From: Anita Gardner
Sent: 11 December 2018 14:11
To: Planning.Responses
Subject: FW: LU/328/18/PL 90/91South Terrace, Littlehampton

To: [REDACTED]
Subject: LU/328/18/PL 90/91South Terrace, Littlehampton

I have had preliminary discussions regarding your application with the Conservation officer today. It is noted that the North Elevation Proposed 955_90ST_x010 is incorrectly titled and should read Existing North Elevation and the Second Floor Plan refers to the bedroom to Flat G as the second bedroom when it is the only bedroom.

Drawing Number:	955_90ST_D104	Revision:	*
Scale:	1:100 @A3	Date:	MAY 2018
		Drawn:	ETG

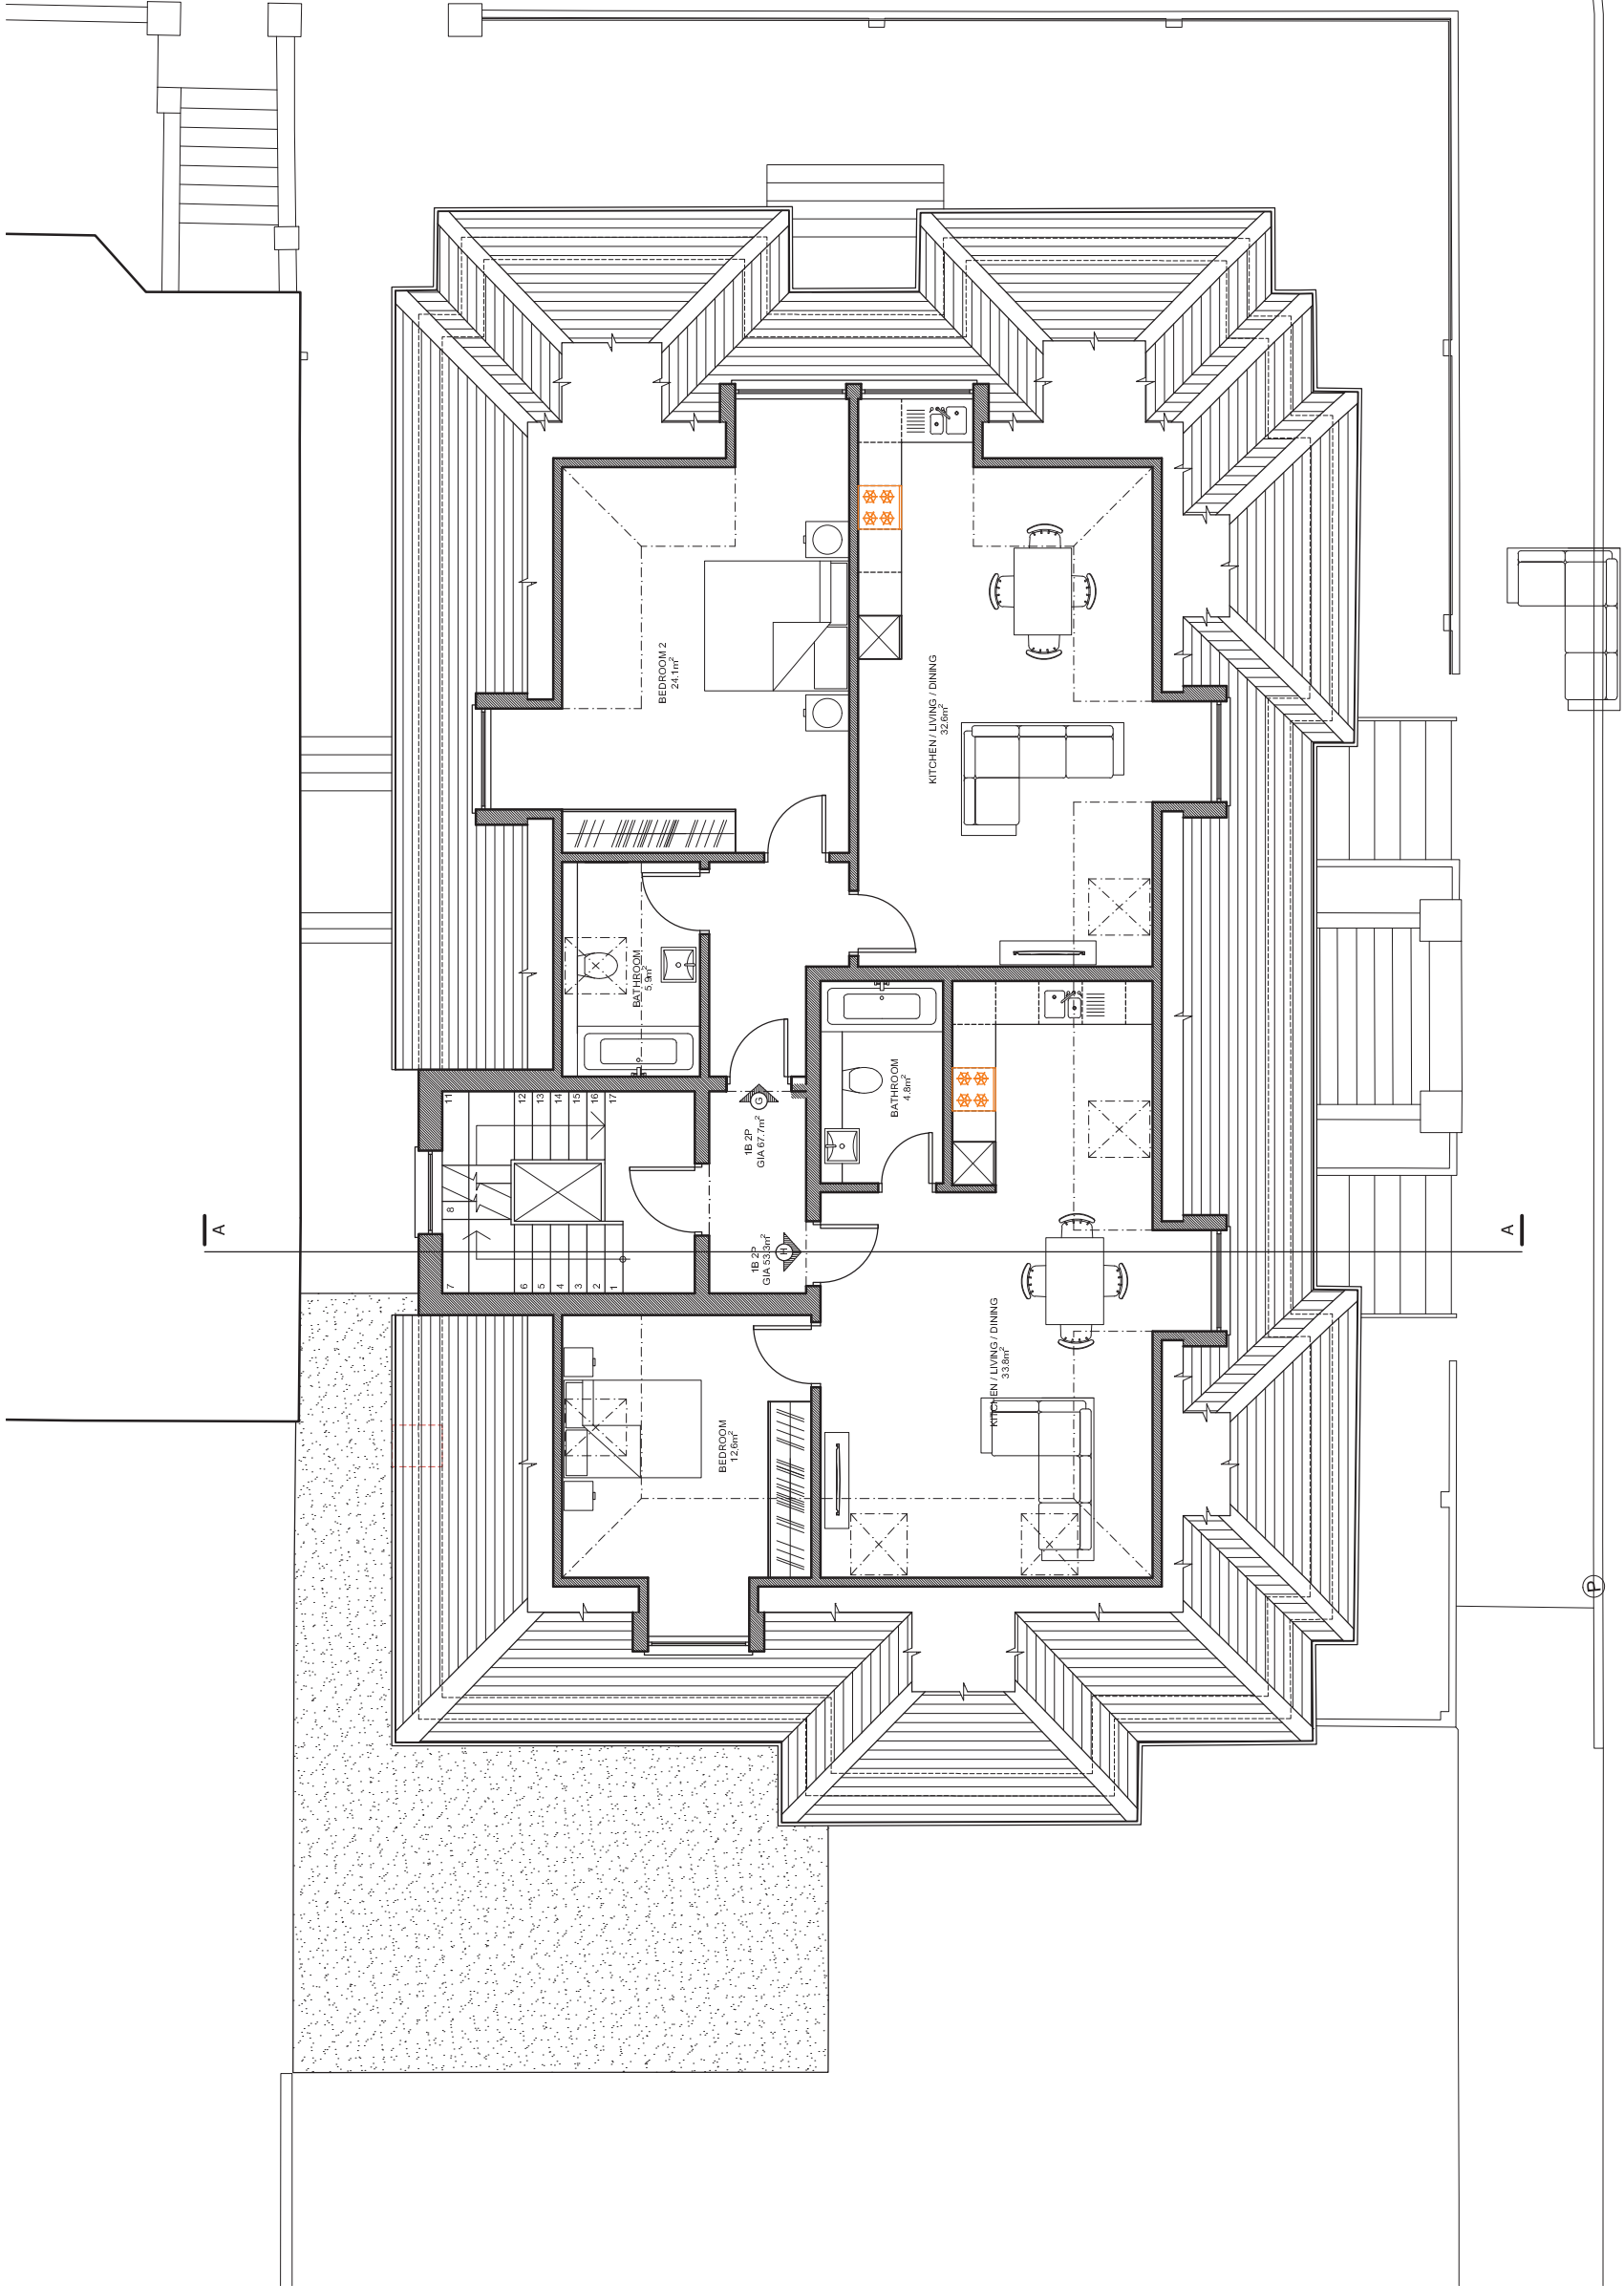
It is also apparent that the access to the roof terrace has been widened and is now visually more prominent in the street scene and adversely detracts from the Building of Character. The railings have also been deleted from the proposal and these made a positive contribution to the character of the area. Accordingly, without prejudice, these items should be amended/included within the submitted scheme.

Please find the amended drawings attached showing the drawing title/labelling errors corrected - thank you for drawing these to my attention.

In regards to the roof terrace access; the width shown in our proposal is the same as was the shown in the previously submitted plans. I now note that the plans and elevations submitted under the previous application do not correspond to one-another. If you measure off the plans you will see that the proposed width is approx. 3.4m, which we have replicated in this application.
